16 October 2017

RMS Reference: SYD17/00339/02  
DP&E Ref: SSD 8310

**RE-DEVELOPMENT OF CURL CURL NORTH PUBLIC SCHOOL  
PLAYFAIR ROAD, NORTH CURL CURL**

Drawing No. AR.DA2.1101
Revision B

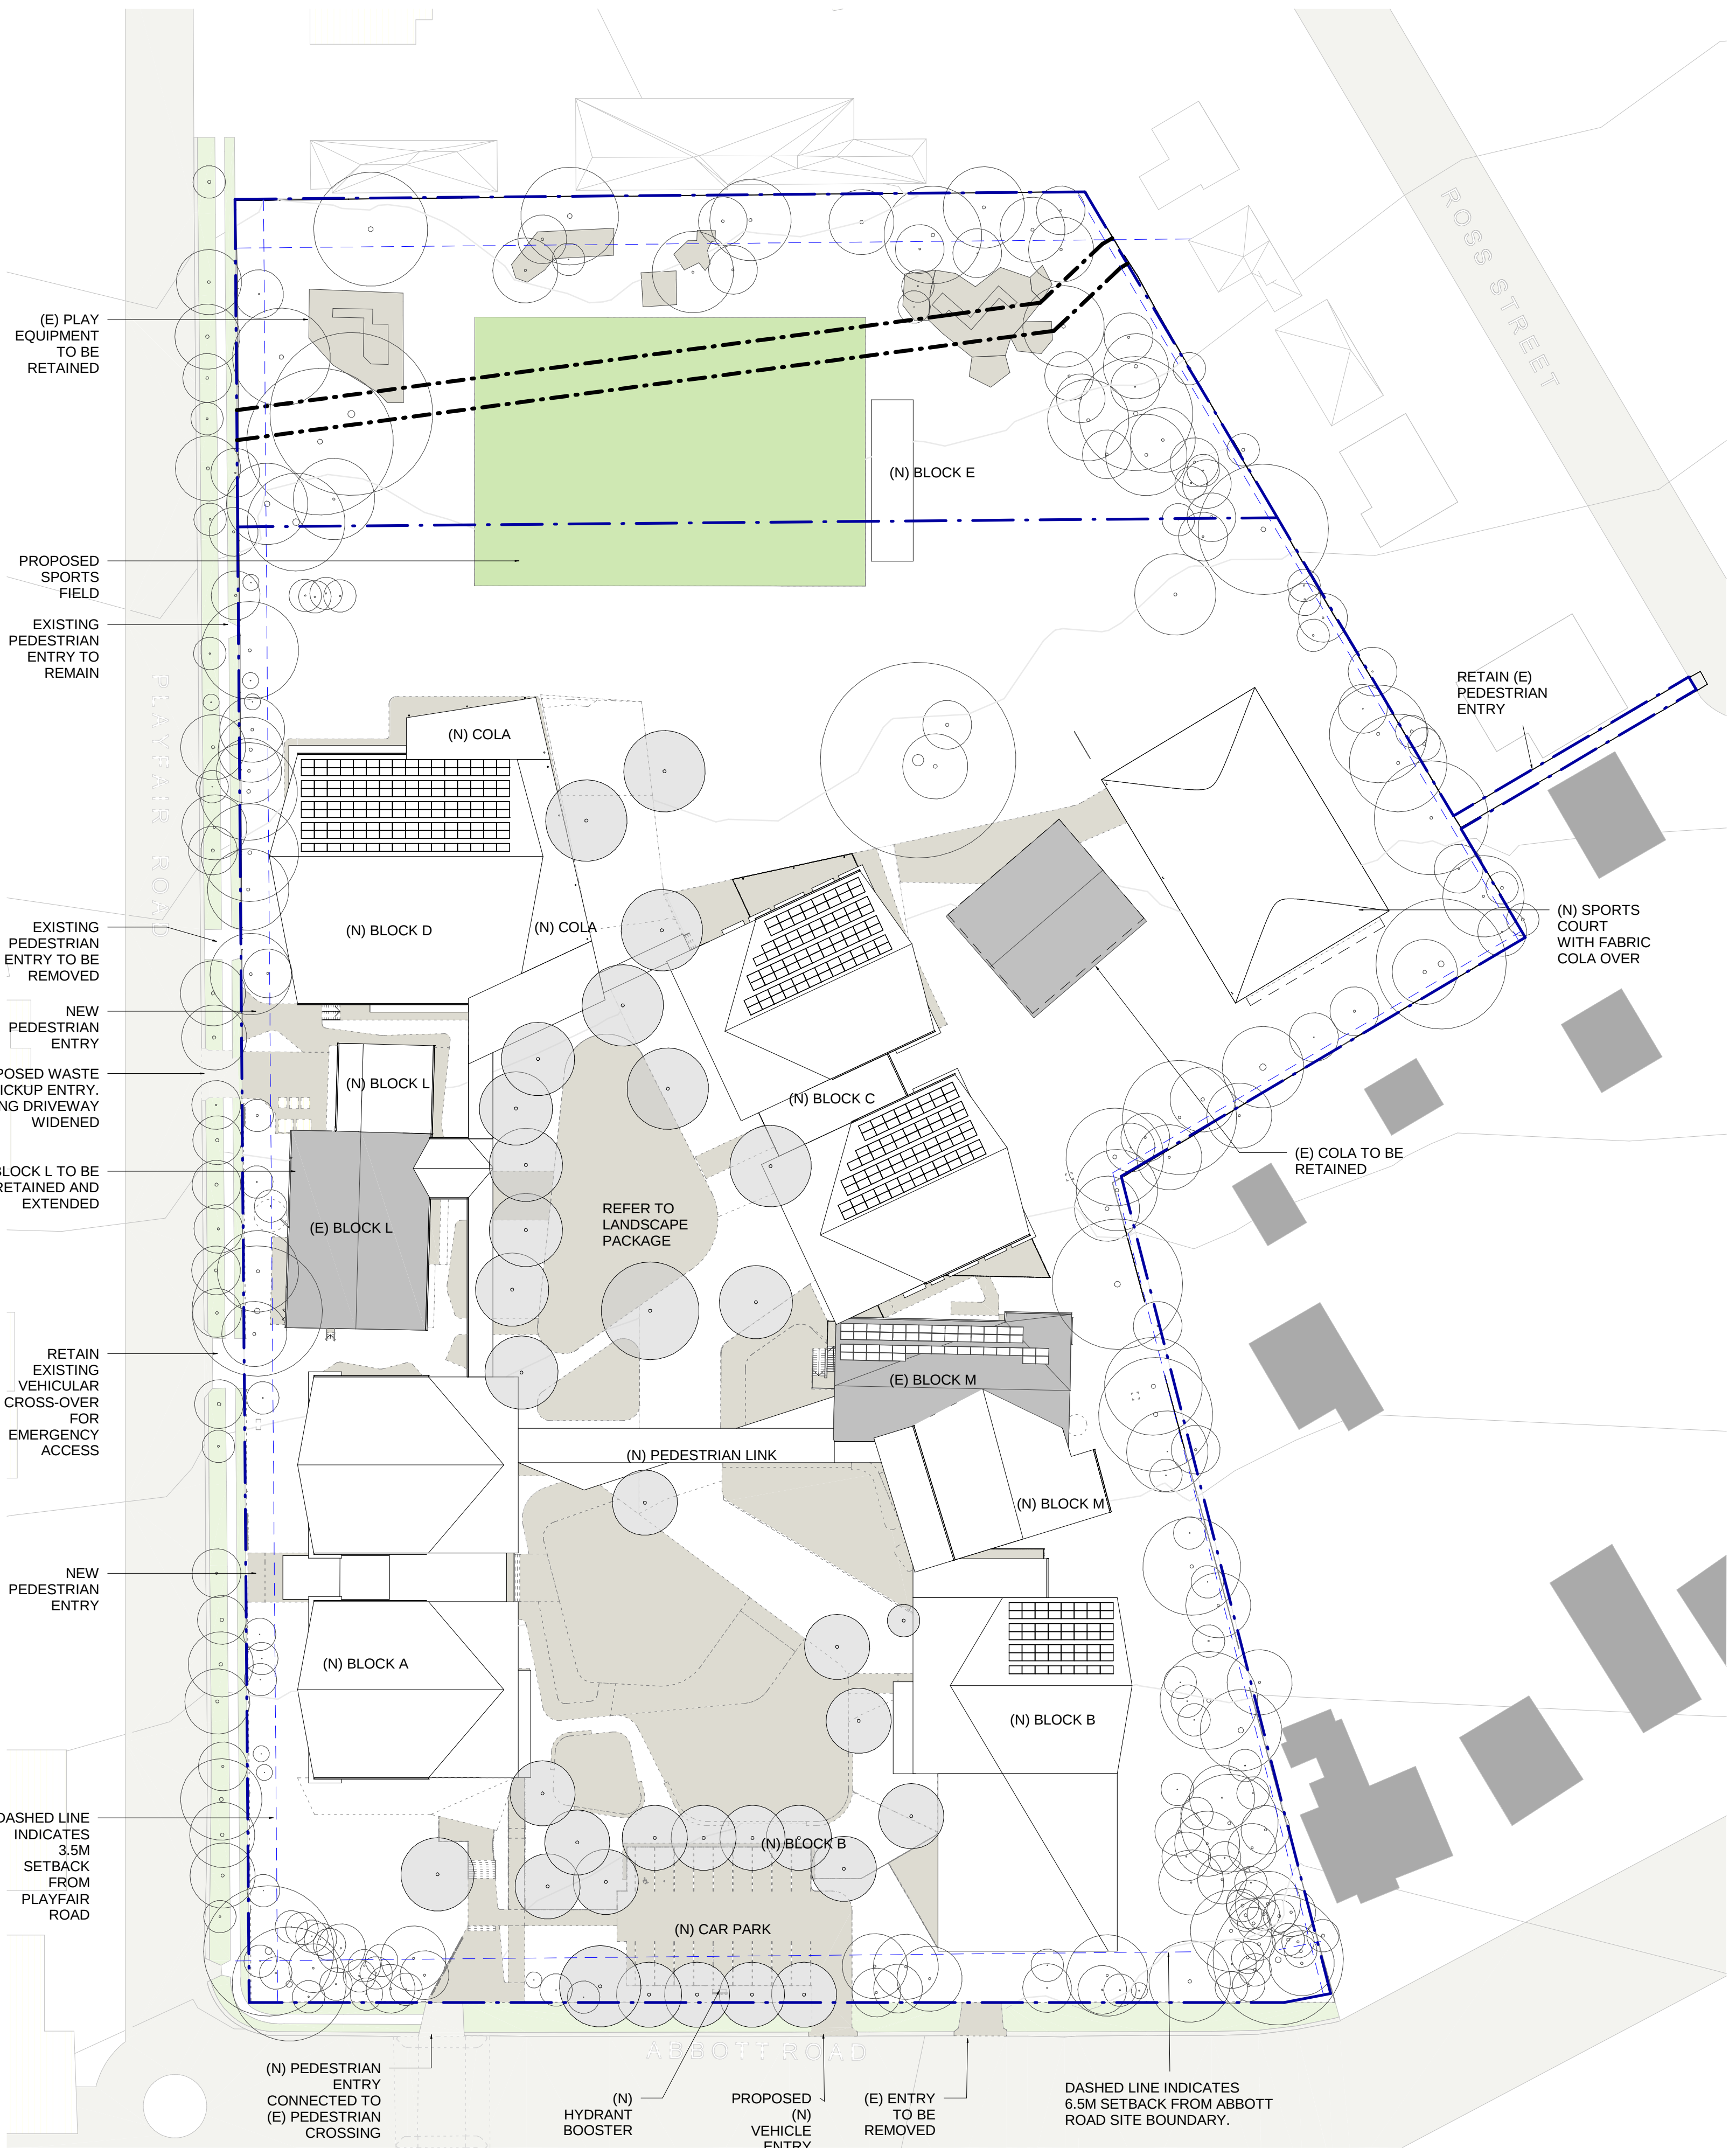
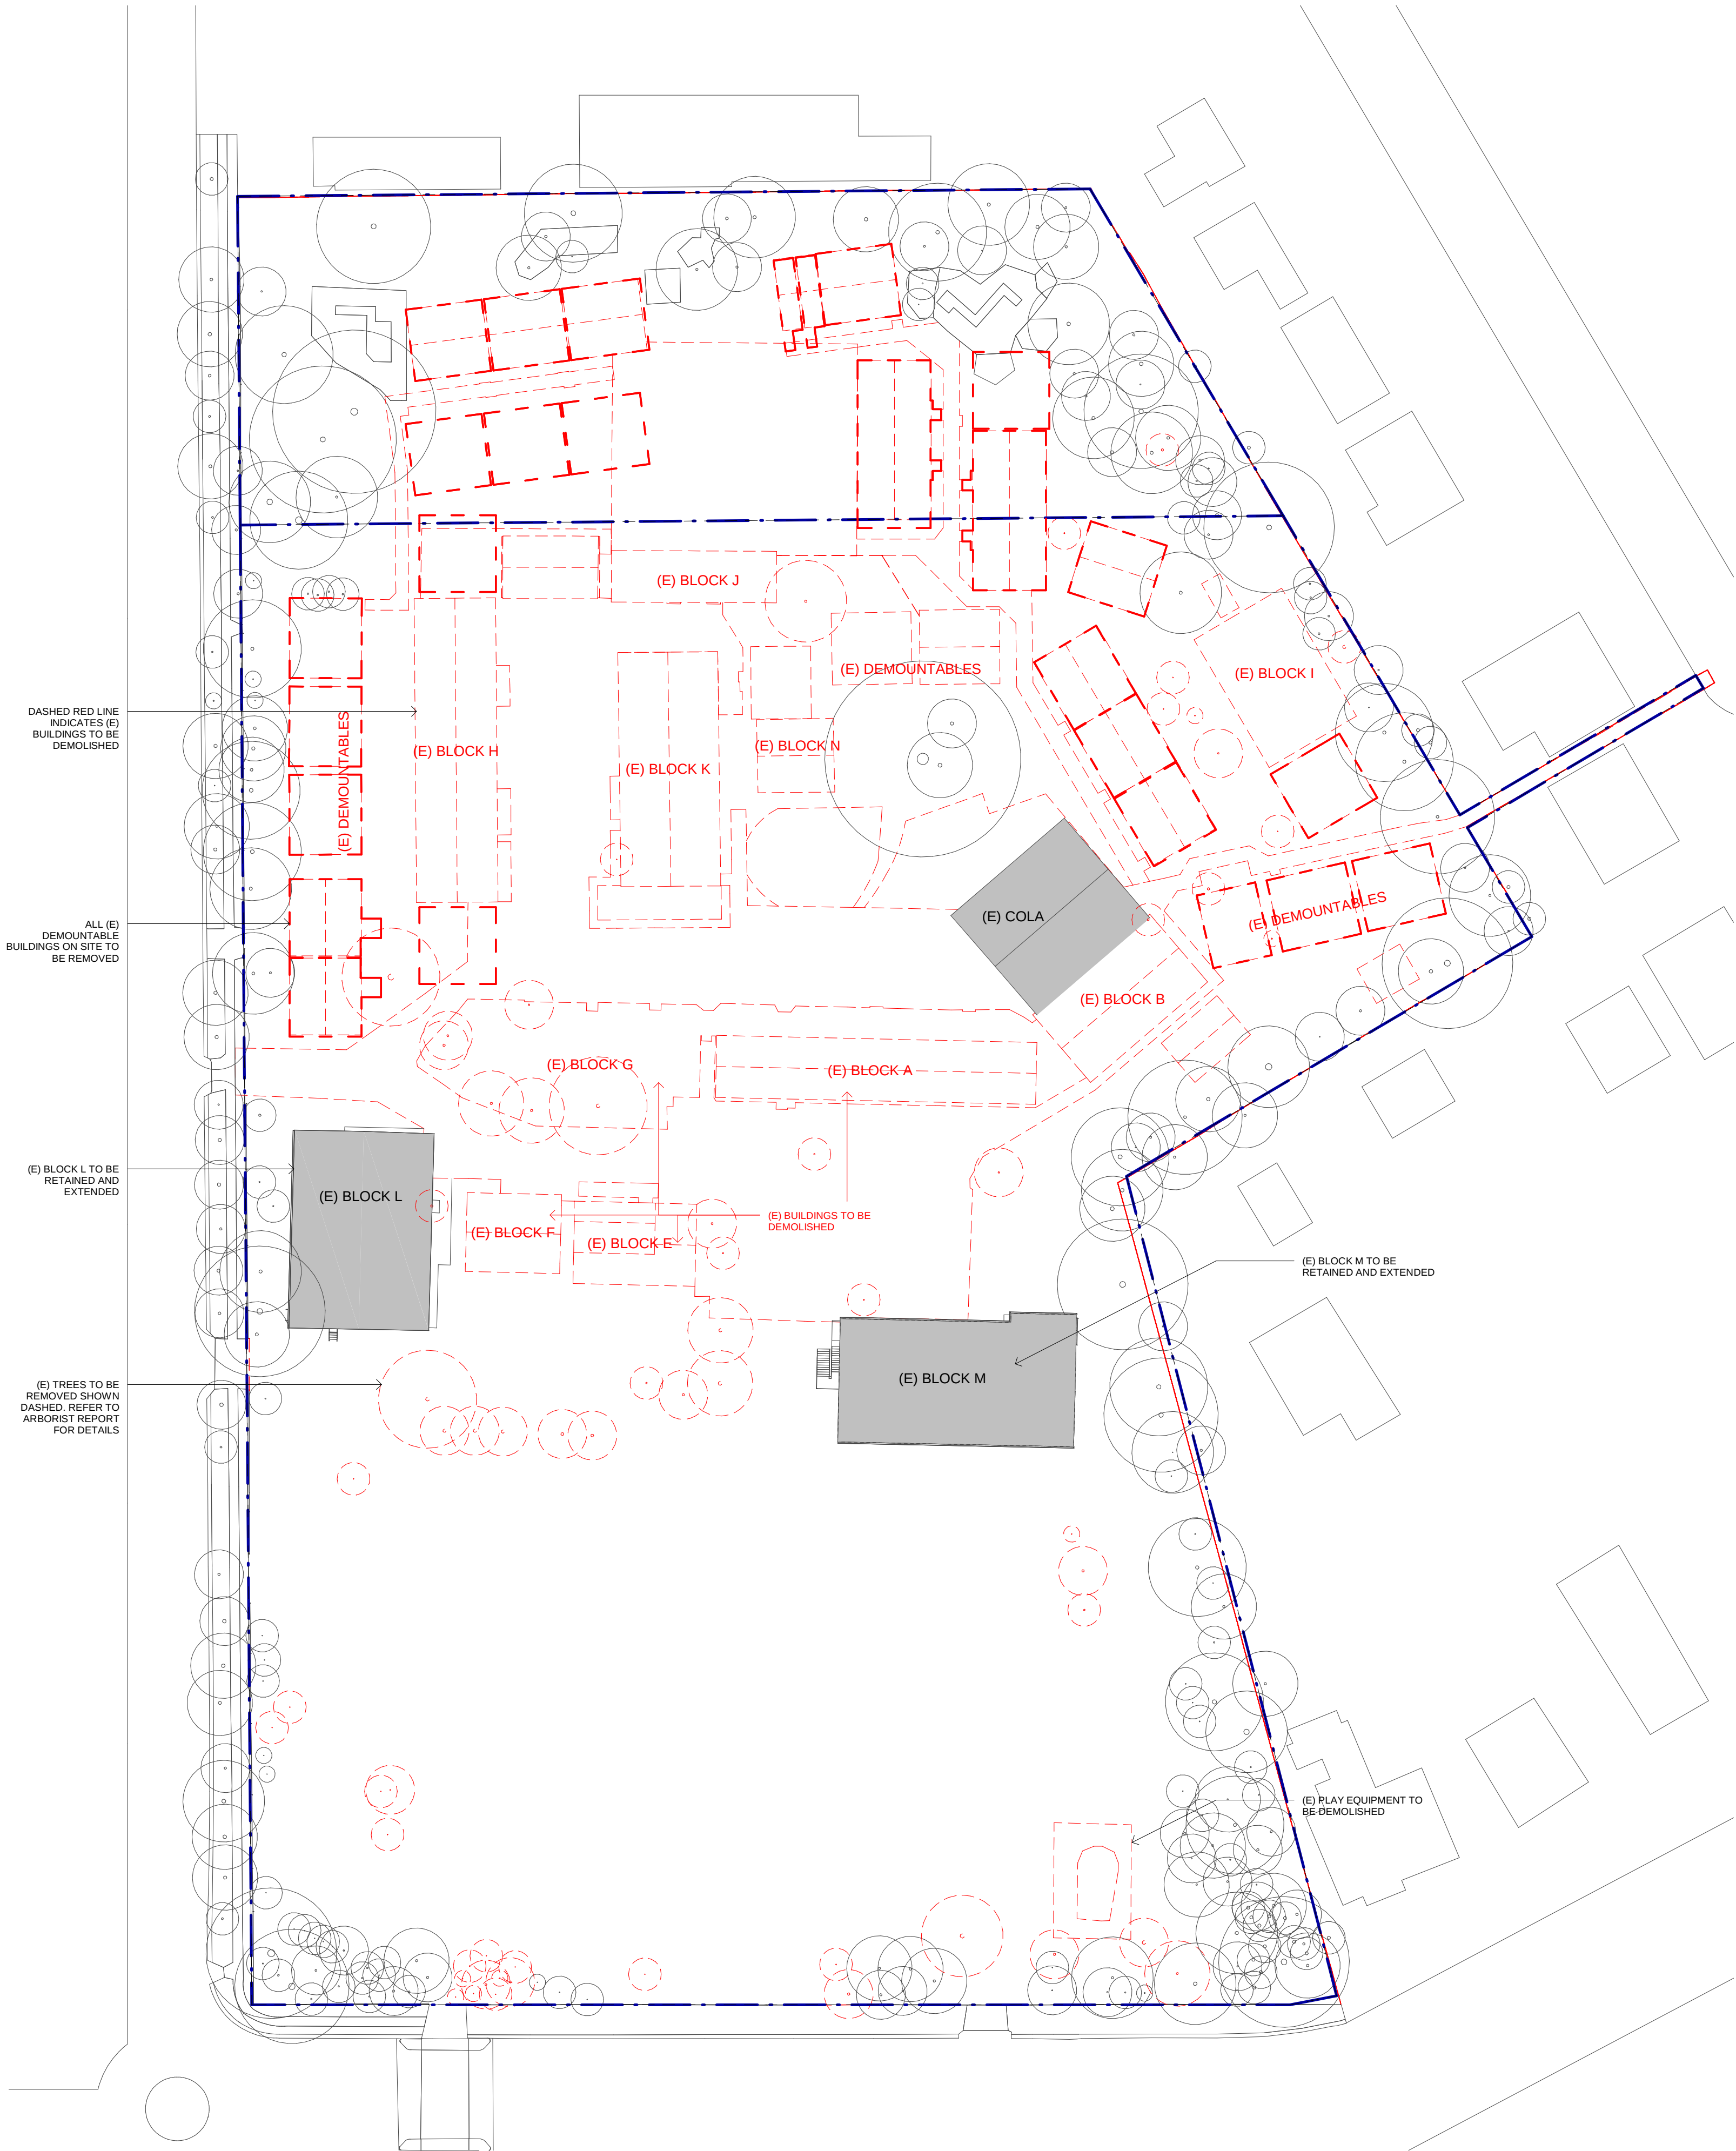
Roads and Maritime has reviewed the submitted information and notes that approximately 93% of the existing staff drive to work and only 16 car parking spaces are proposed for 76 staff and visitors. Lack of on-site parking will result in on-street parking issues. Roads and Maritime recommends that adequate parking is provided on-site.
